WALBERTON PARISH COUNCIL
INCLUDING FONTWELL AND BINSTED
Parish Council Office, The Pavilion, The Street,
Walberton, Arundel, West Sussex, BN18 0PJ

Re: Planning application WA/93/20/PL: Land East of Tye Lane, Walberton.

Walberton Parish Council wishes to register an **objection** to this application. We have the following concerns.

Appendix B
Traffic Flow Diagrams

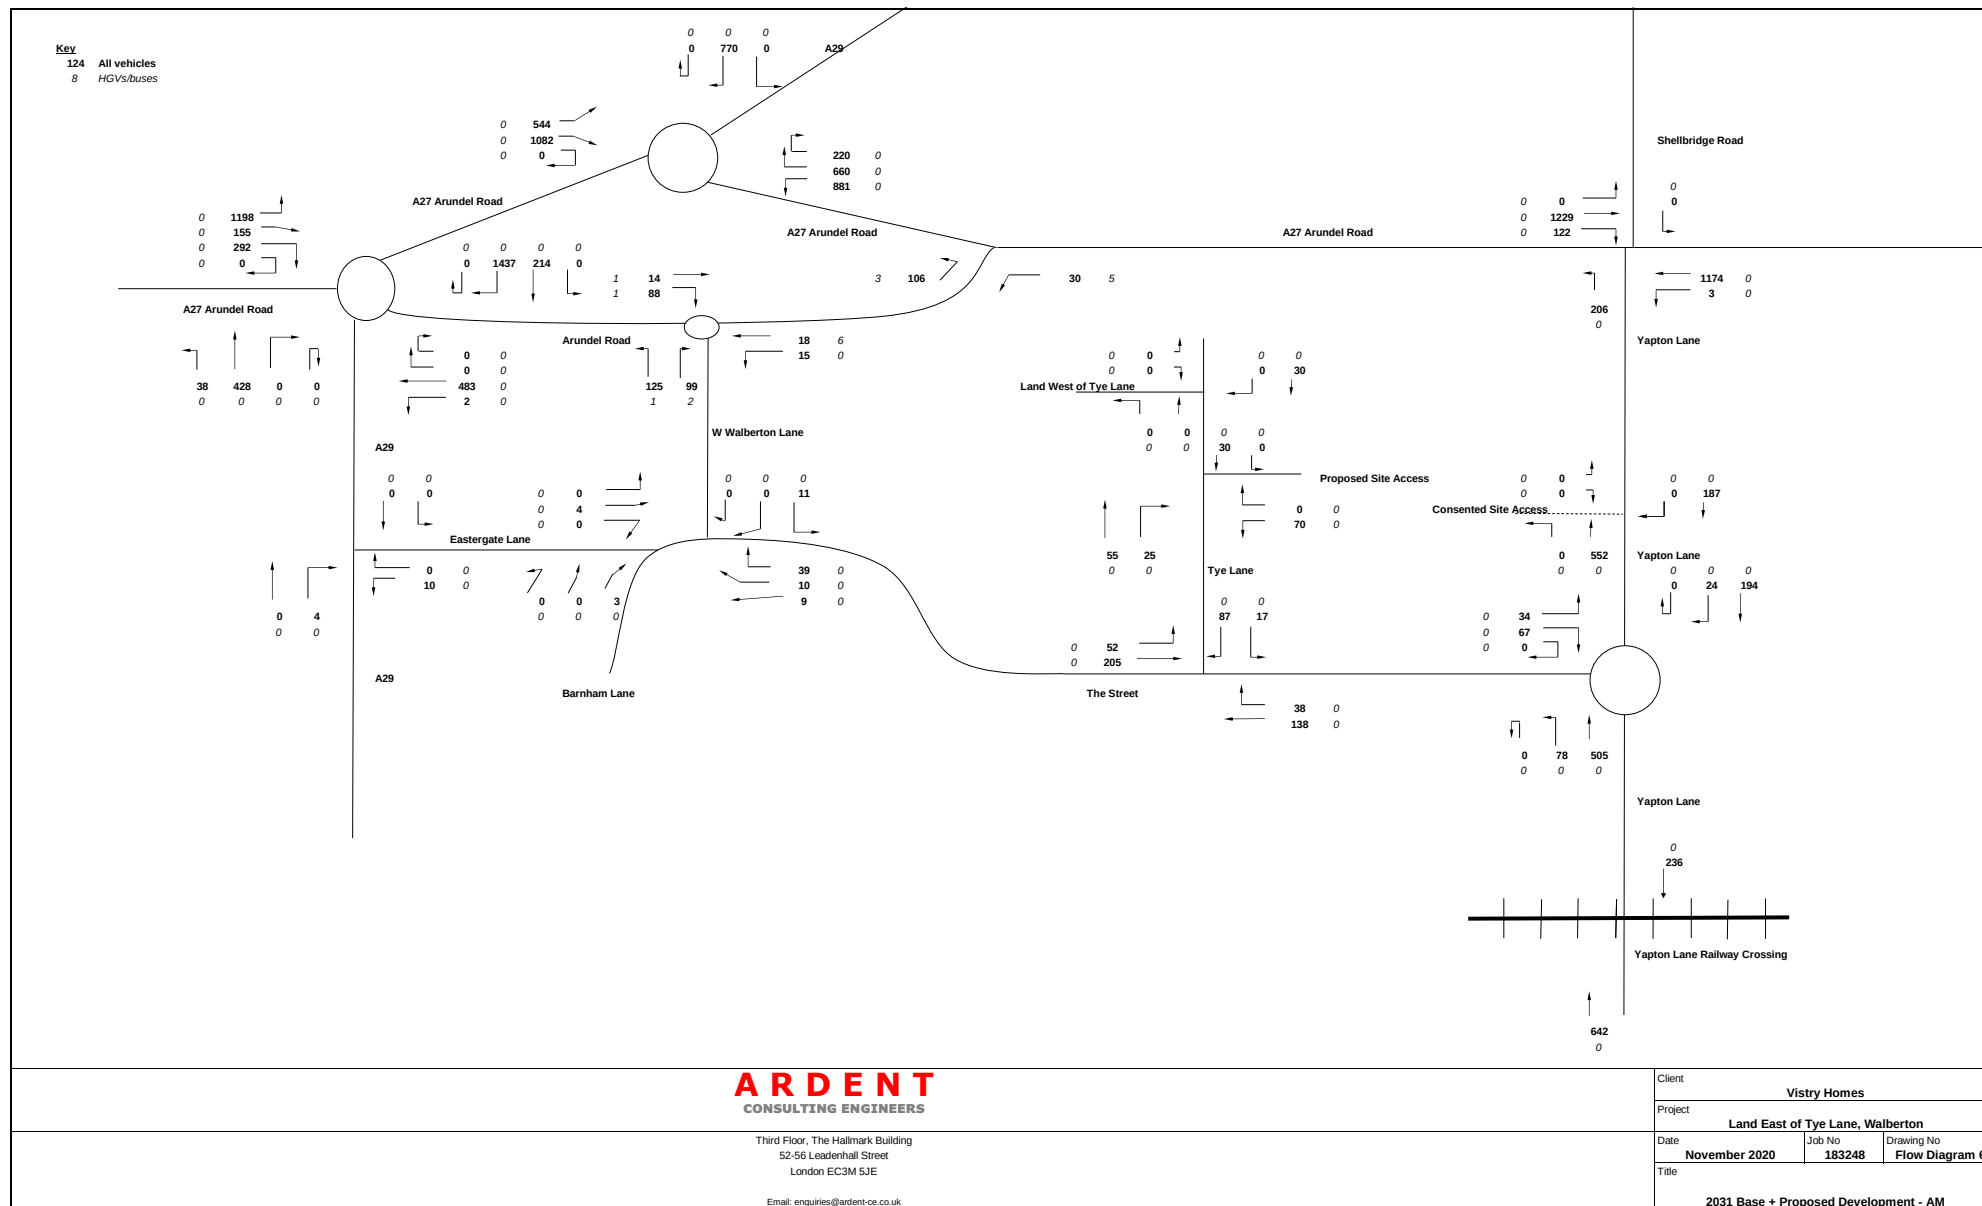
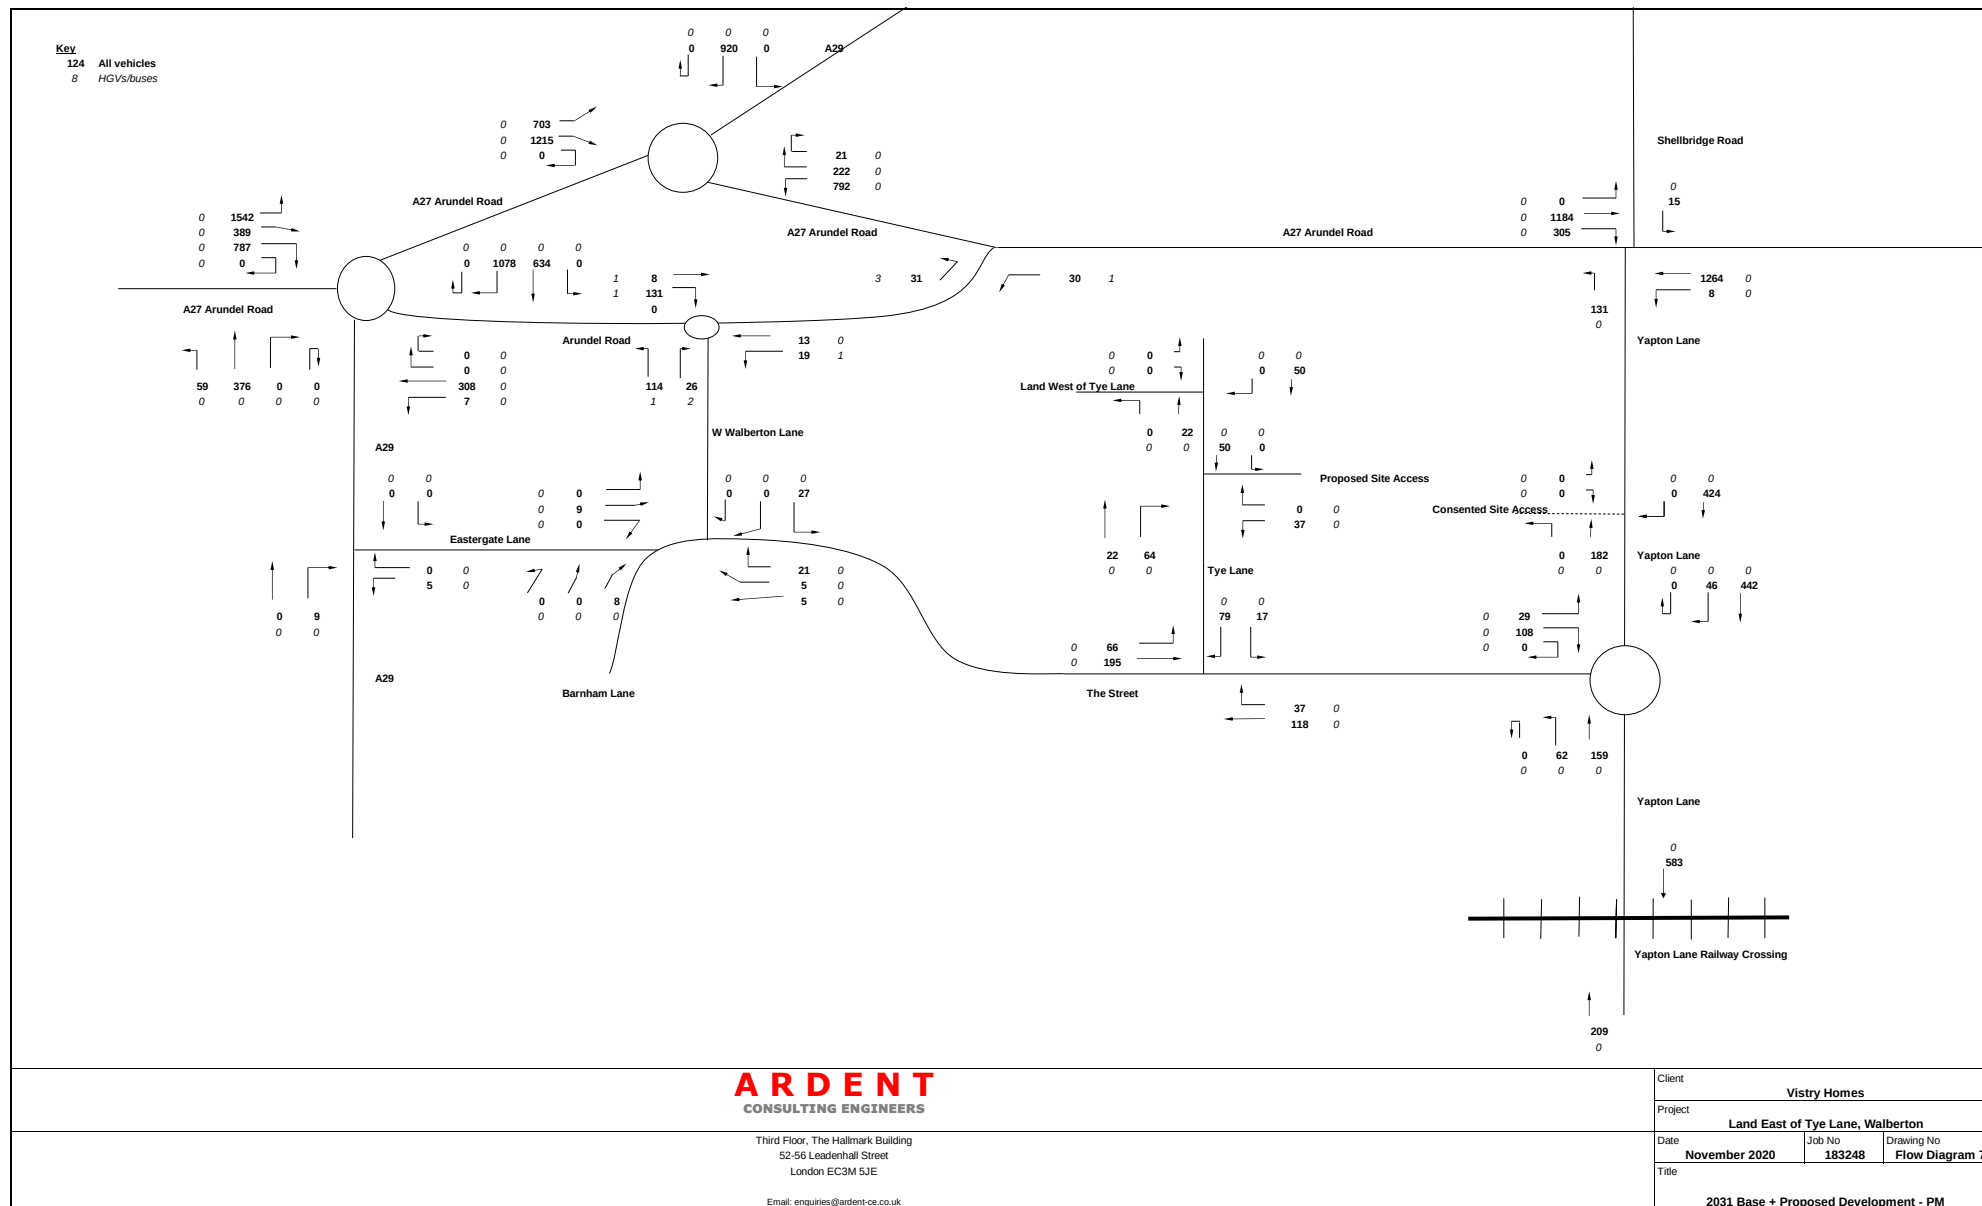
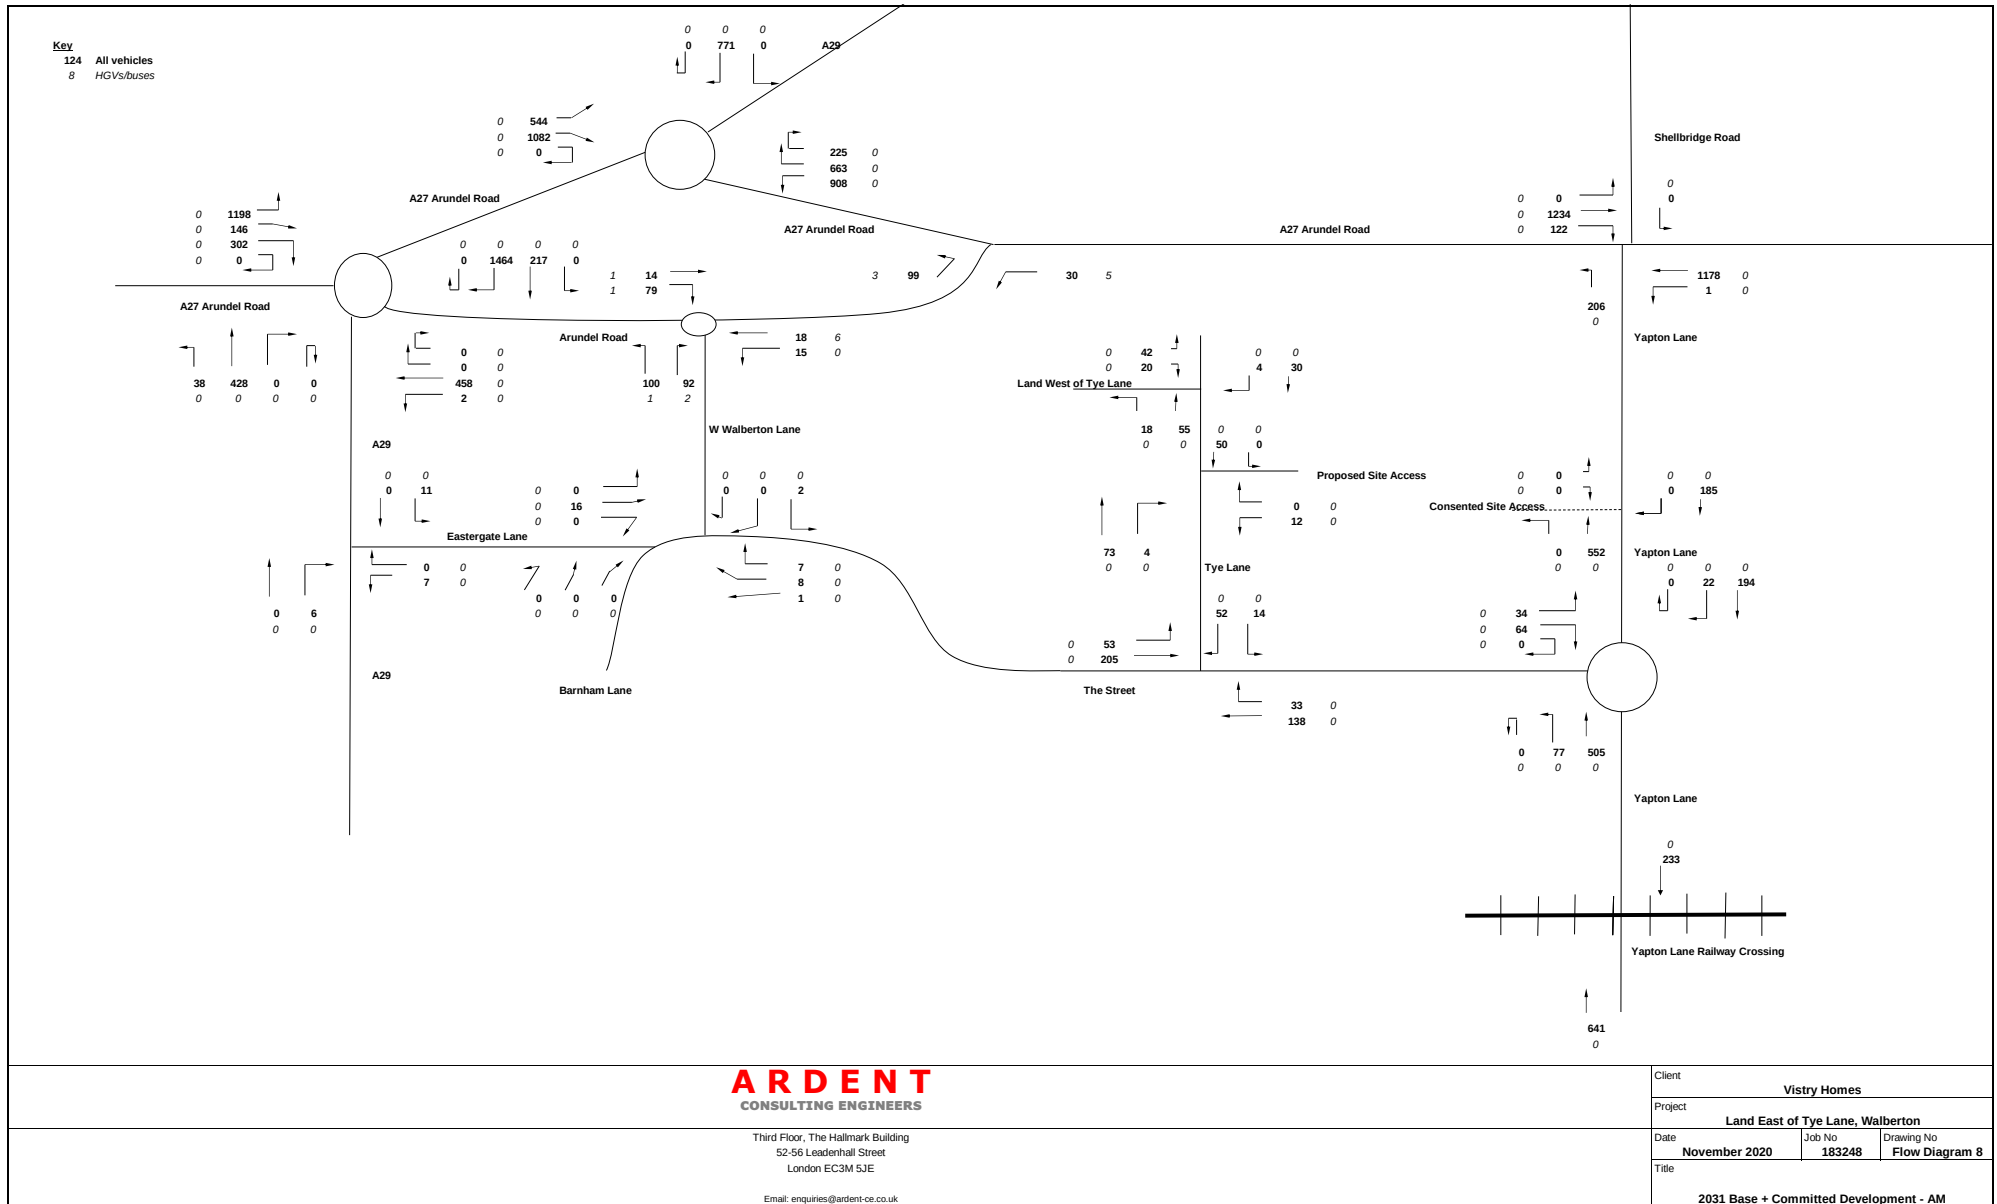
A number of Traffic Flow Diagrams are provided to illustrate changes in traffic flow patterns. However, they seem to have incorrect data.

- The 2031 base numbers used refer to 50 vehicles going northwards up Tye Lane to a dead end and 30 heading southbound from this dead end. As there is no reason for this degree of traffic to head into a dead end, it appears that this reflects a prediction for travel when the road has not been severed by the A27.

- These numbers get added to the site traffic proposed flows to generate the reports for increased traffic after developments have been built, where no traffic heads up the dead end. We presume that no traffic is indicated heading North out of the development as the road is impassable.

- Adding a base number for 2031 for traffic with a fully passable Tye Lane to a numbers post-closure for estate traffic as appears to have been done gives meaningless numbers. The 2031 base numbers for The Street, West Walberton Lane etc. will be incorrect if traffic has been allocated to Tye Lane and the A27 where it cannot go so will falsely reduce the numbers for our local roads. This will give a reduced indication of the real impact of the traffic to the local roads.

- There would appear to be very few vehicle users predicted for 175 (soon to be 205) dwellings. For example, the base traffic and additional from proposed developments indicates 70 movements leaving in the am peak, and 6 returning in the pm peak.

- Assuming only two residents per dwelling and all movements to be due to the Avisford Grange development suggests only 17% of residents (70 movements out of 410 residents) will travel during peak times to work or school.
